**Consultation Response from KC,  
Lead Local Flood Authority**

**2025/93229 Land off, Westgate, Cleckheaton, BD19 5DR**

**Discharge of details reserved by conditions 15 (drainage), 33 (waste), 37 (cycle parking), 41 (LEAP) on previous permission 2021/93567 for demolition of existing commercial buildings and erection of 180 dwellings with associated works**

**Date Responded: 30<sup>th</sup> December 2025**

Inlet Access, Maintenance and Low Flow Channel Details
Scale 1:50

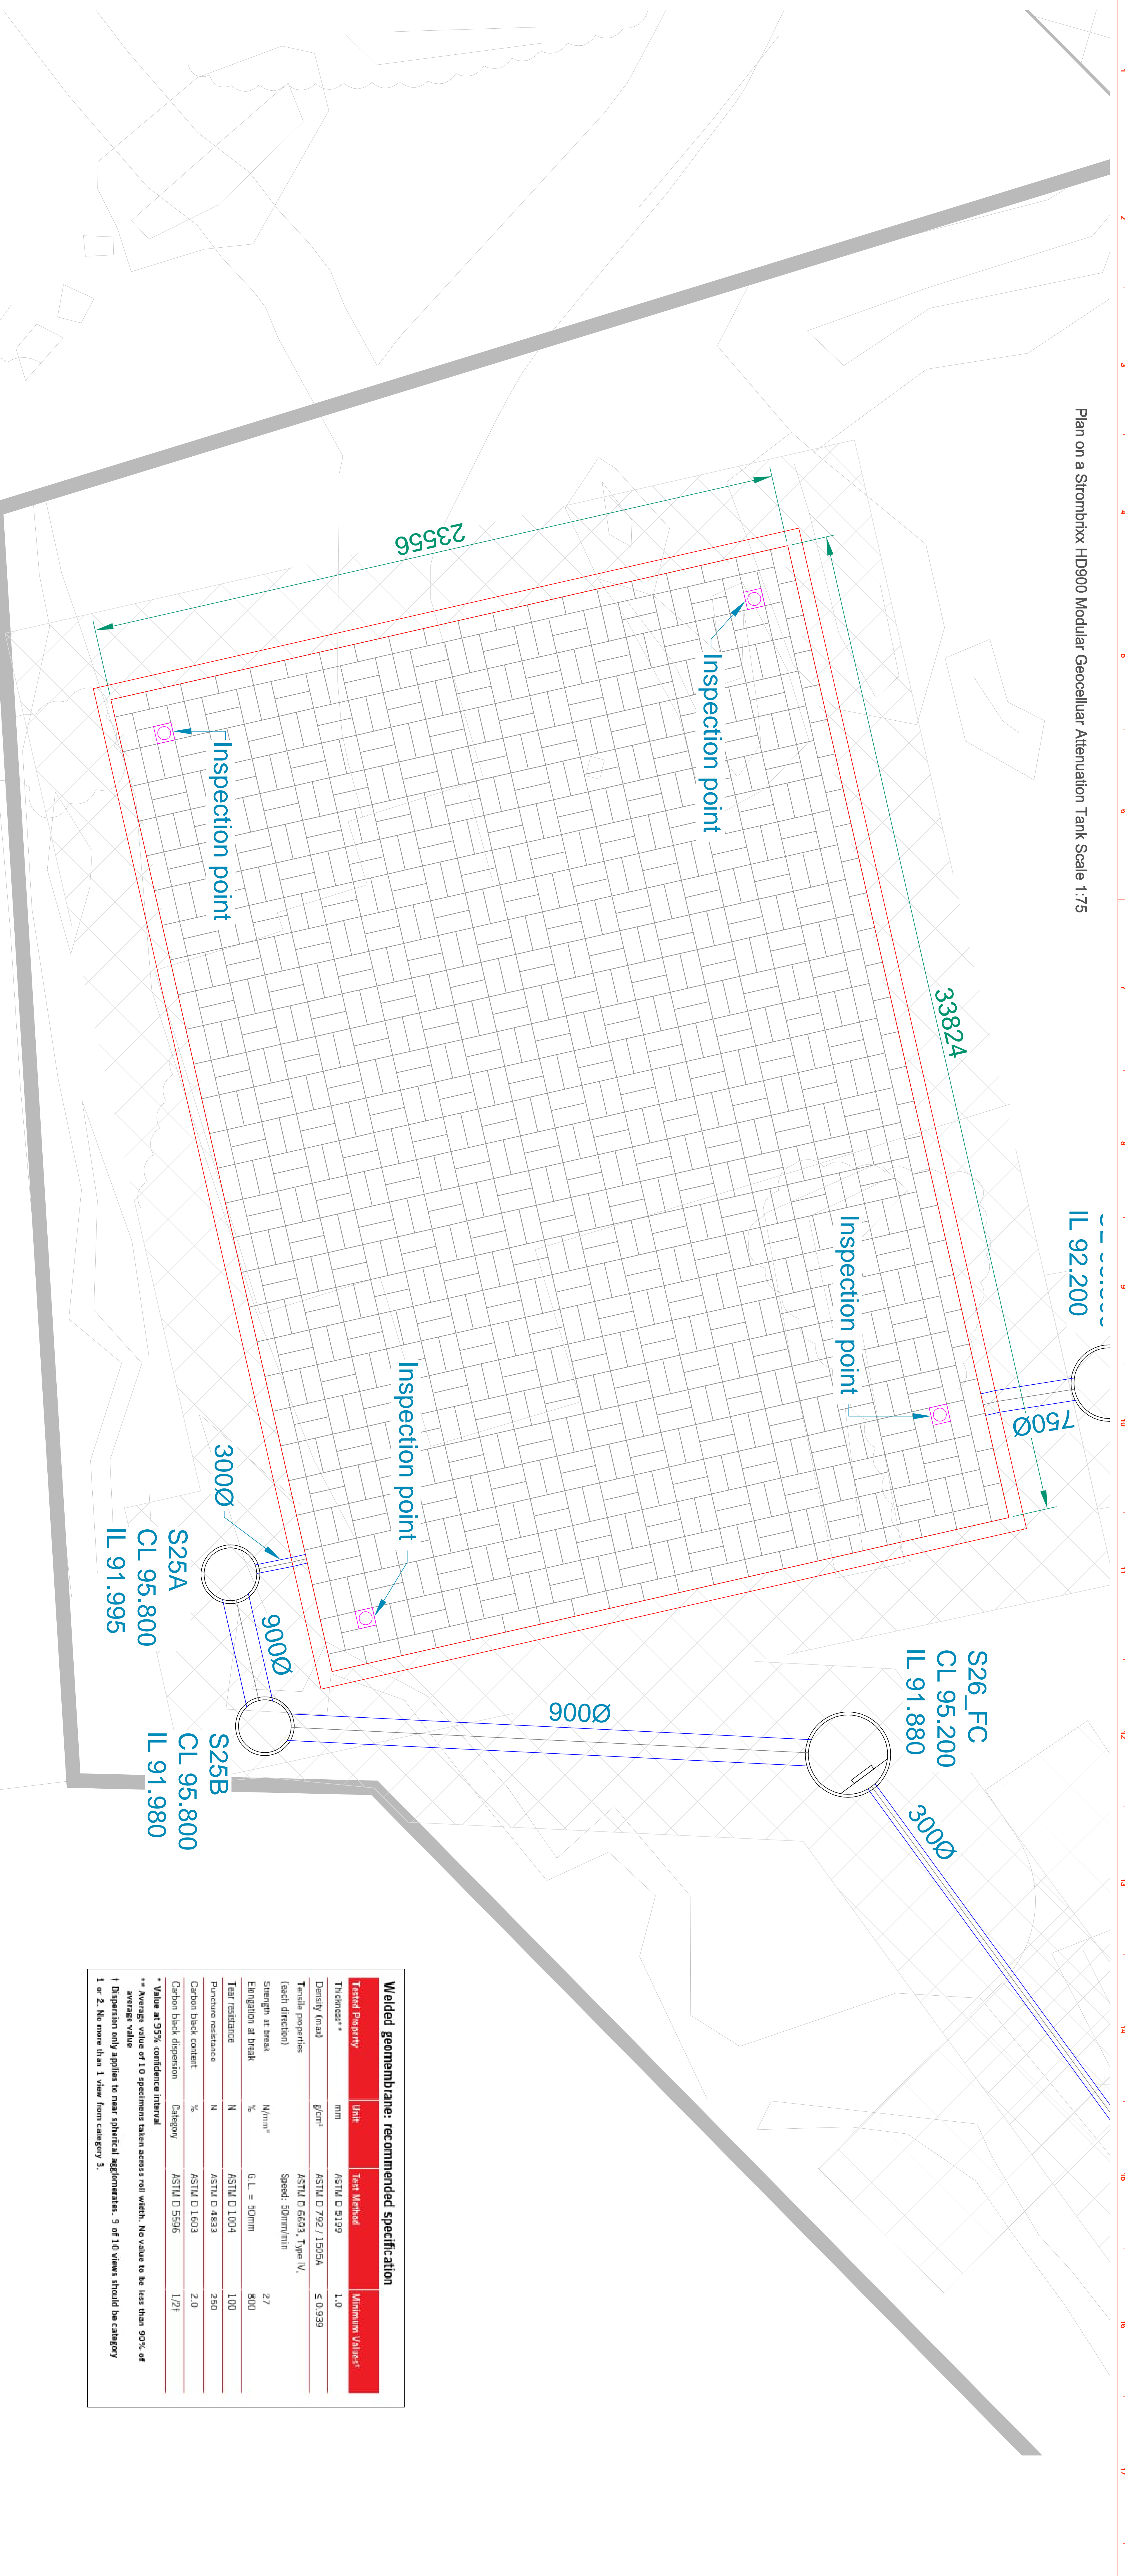
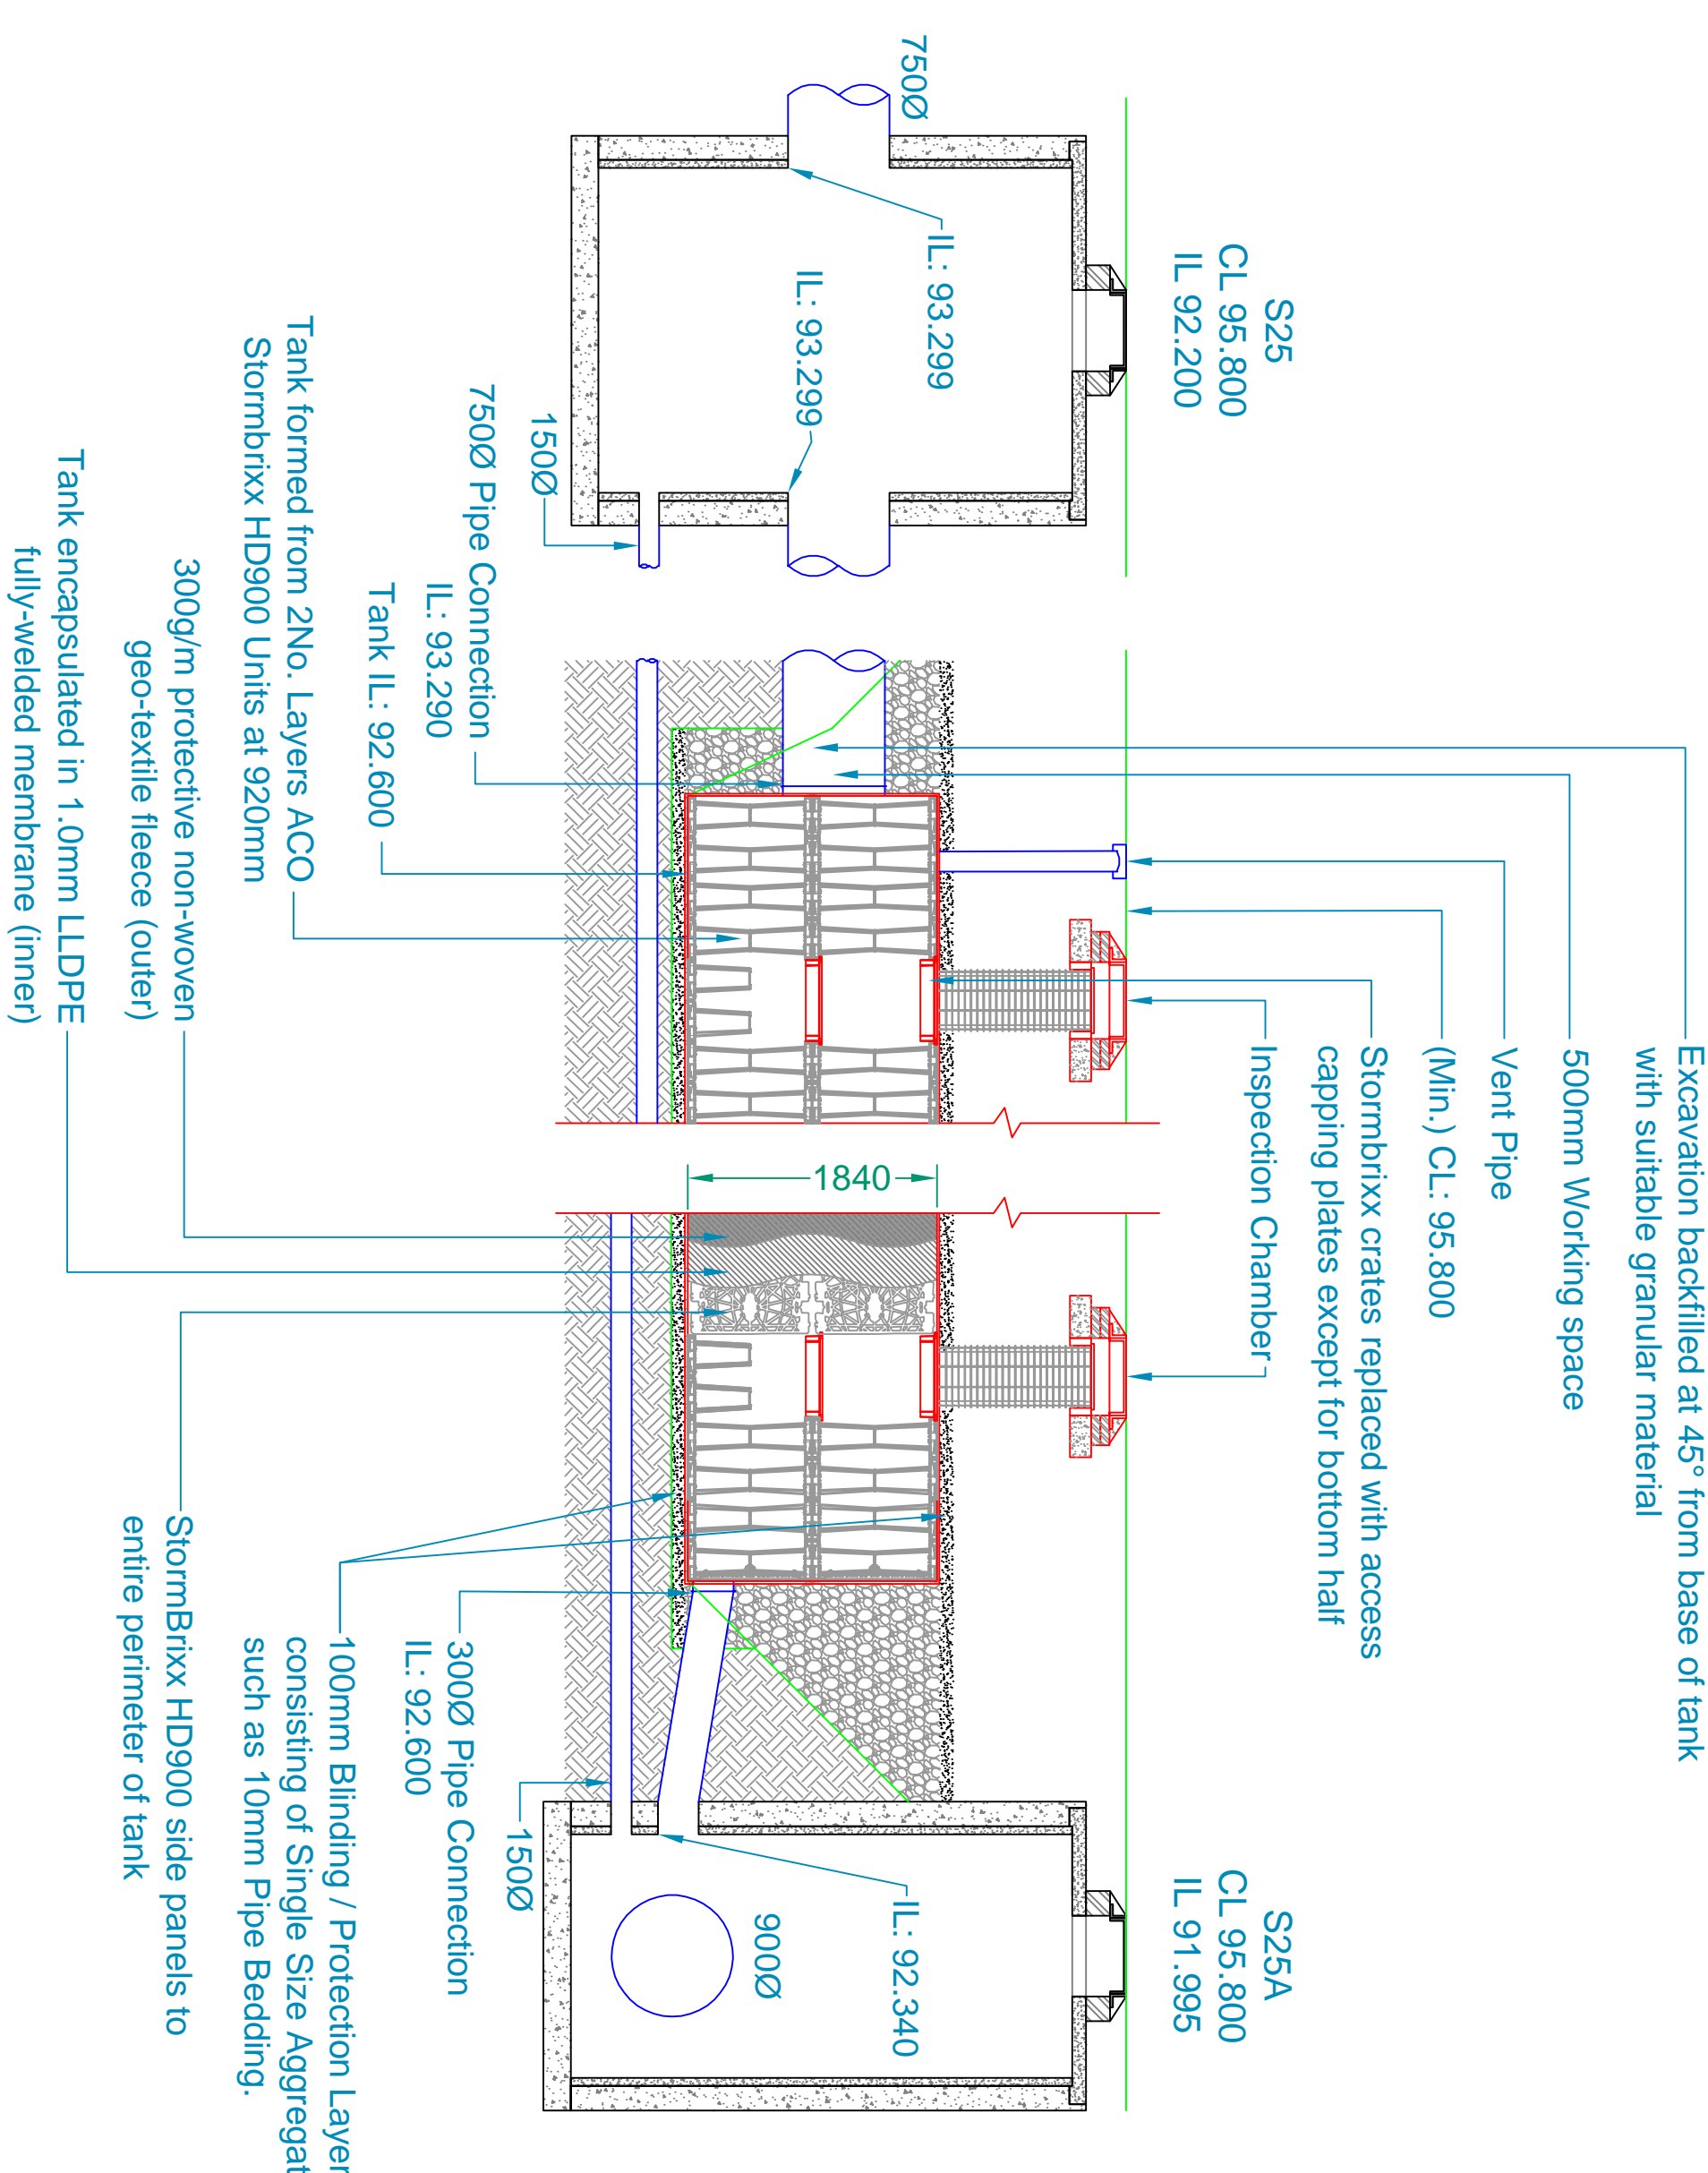
A full drawing of the tank with dimensions and segment dimensions is required. It is not clear how the 150mm low flow pipe is to be incorporated. It is not clear whether the 4 access points are concrete man access or the smaller system both stated in the manufacture's guide supplied.

S25 - SUMP MANHOLE

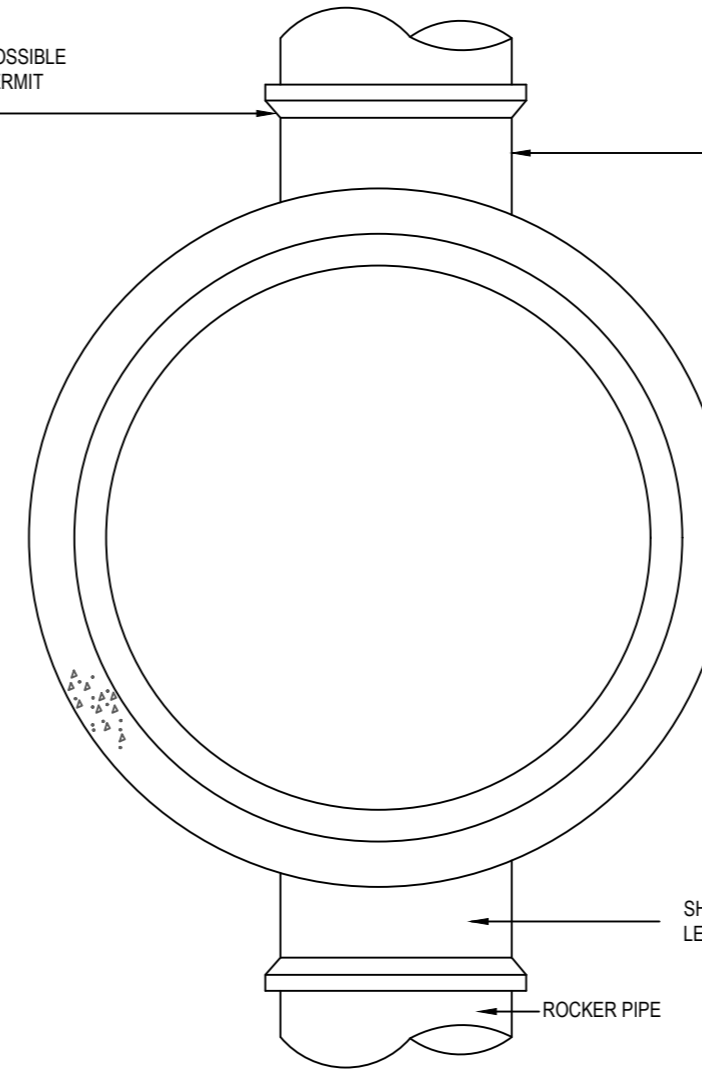
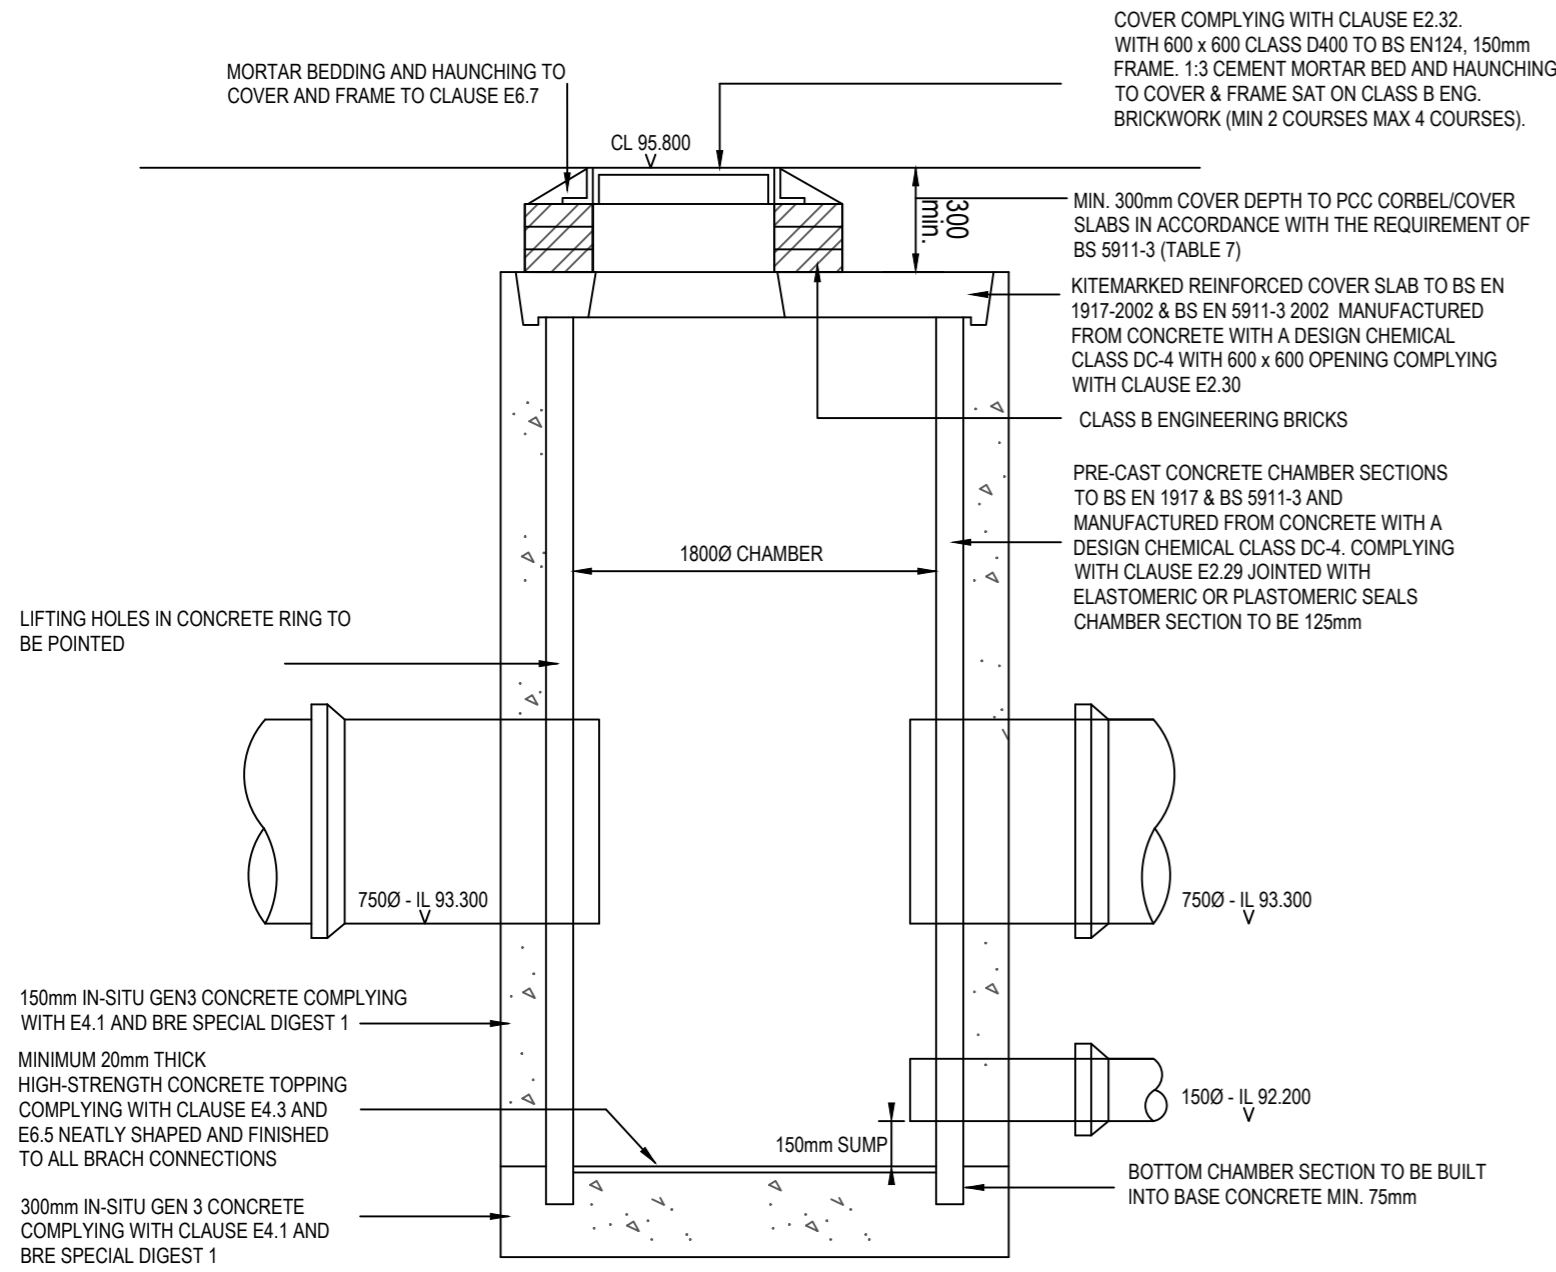
A drawing showing a catchpit manhole at S25 is required for completeness to best prevent siltation of the tank. This must be reflected in the supplied maintenance plan.
